Technical Memo

Re: One City Center – City Deli Kitchen Exhaust Hood Existing system

KITCHEN HOOD SKETCH

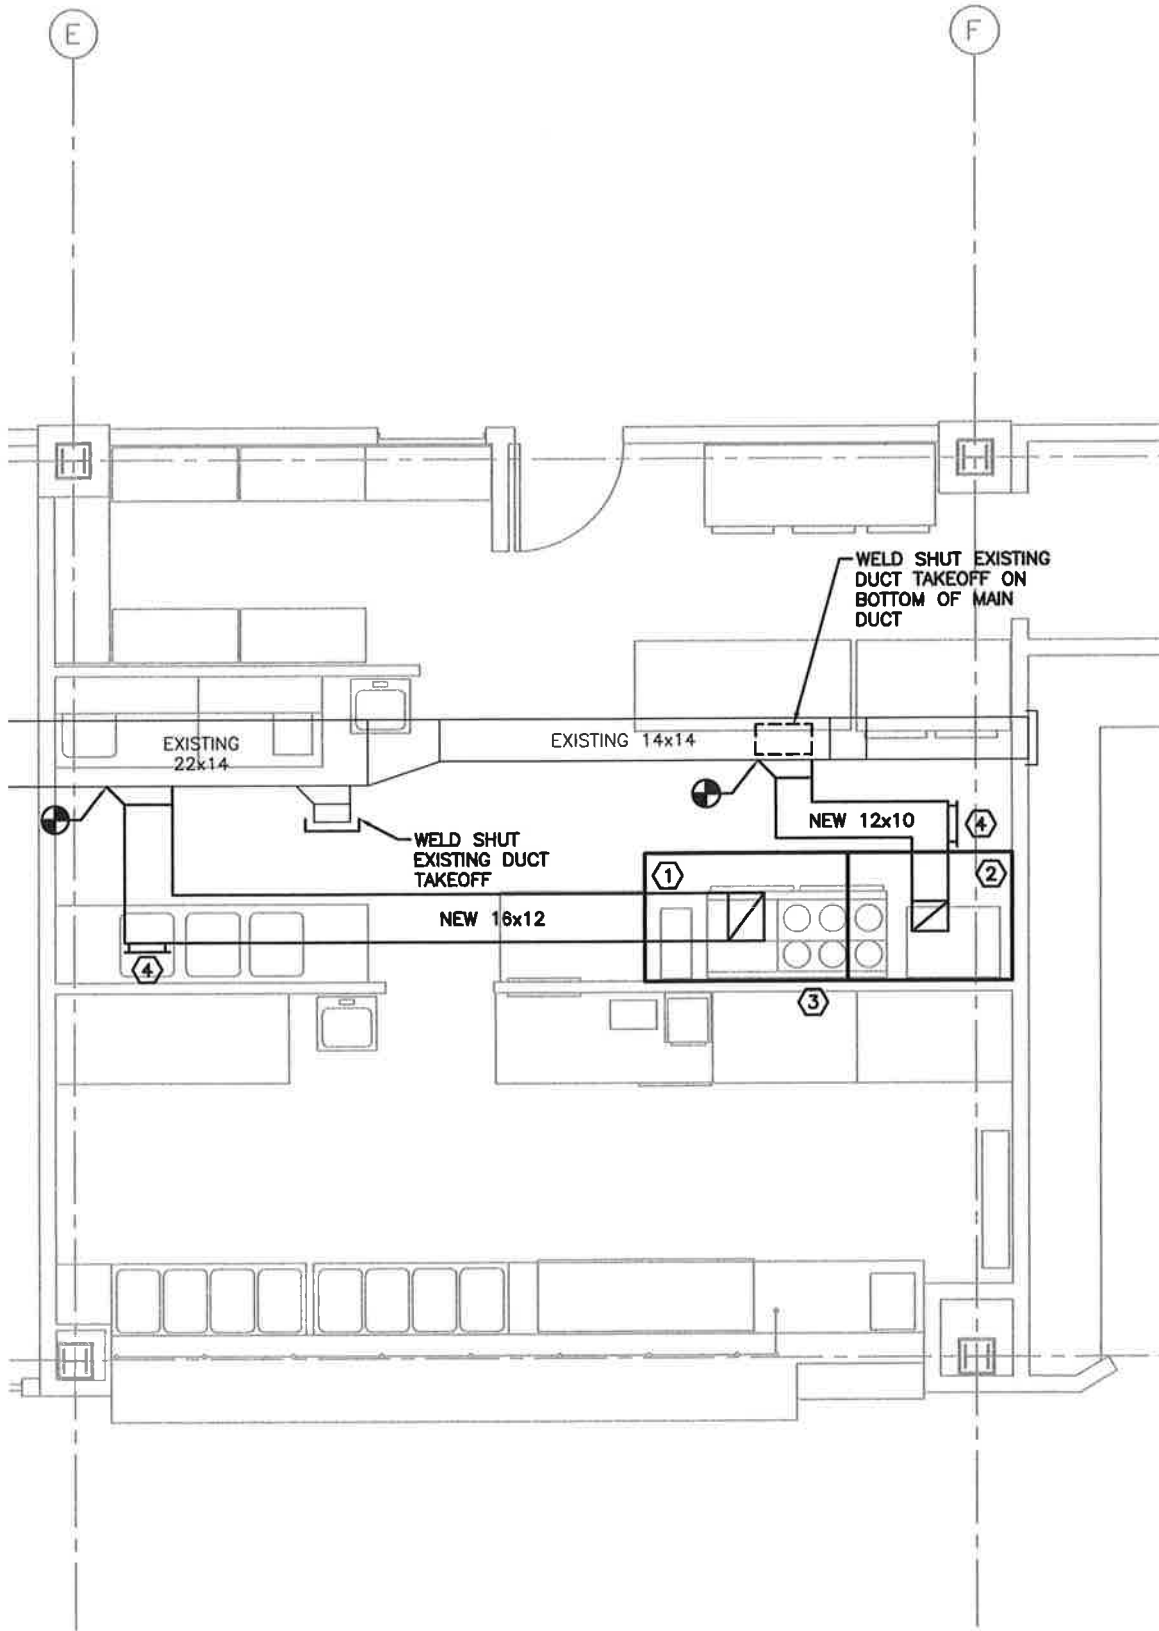
Item 1: Clearance to combustibles: Some new gypsum board partitions have been added around the existing ductwork since its original installation. These partitions are considered limited-combustible and shall be modified to meet the minimum of 3 inches per section 4.2.1 of NFPA-96-2008. Similarly the grease duct shall be wrapped with an approved fire barrier to allow for a zero clearance reduction per NFPA-96 section 4.2.3 in tight areas as shown below where minimum clearances cannot be made.
